From: ian Fletcher
Sent: Tue, 19 Jan 2021 12:51:45 +0000
To: Michelle Hendry
Subject: RE: CHe/20/00292/FUL - 27 Barn Close

From: [Michelle Hendry](#)
Sent: 19 January 2021 10:48
To: [ian Fletcher](#)
Subject: CHe/20/00292/FUL - 27 Barn Close

proposed side

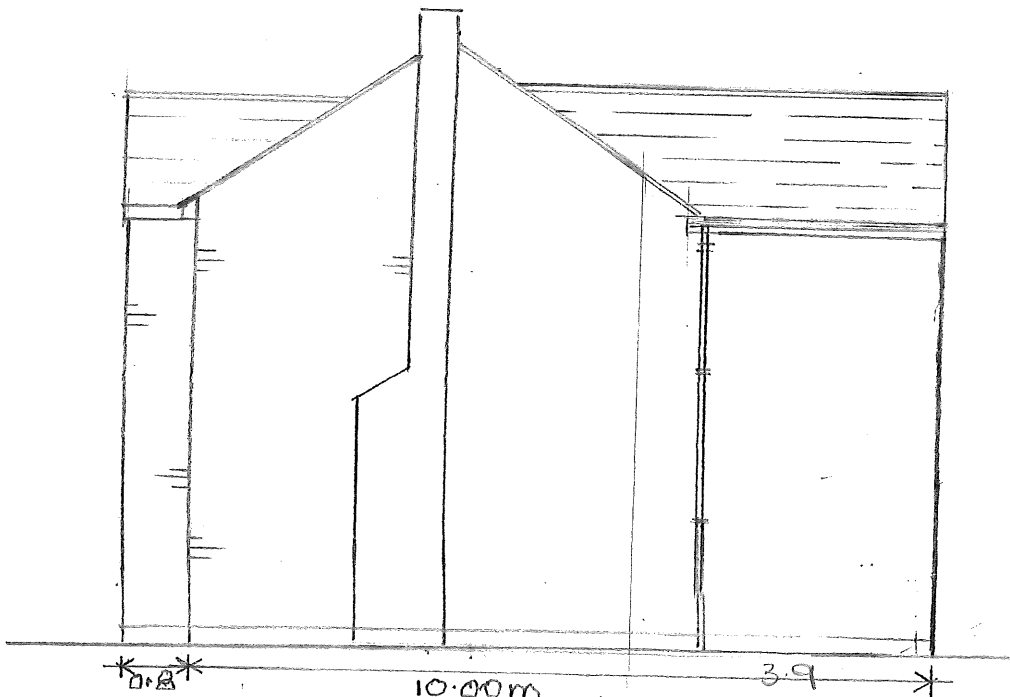
All the email needs to do is answer the following question are you ok with me adding the line in the proposed side elevation drawing.

I would confirm that I have no objection and happy with you adding a line to the side elevation drawing.
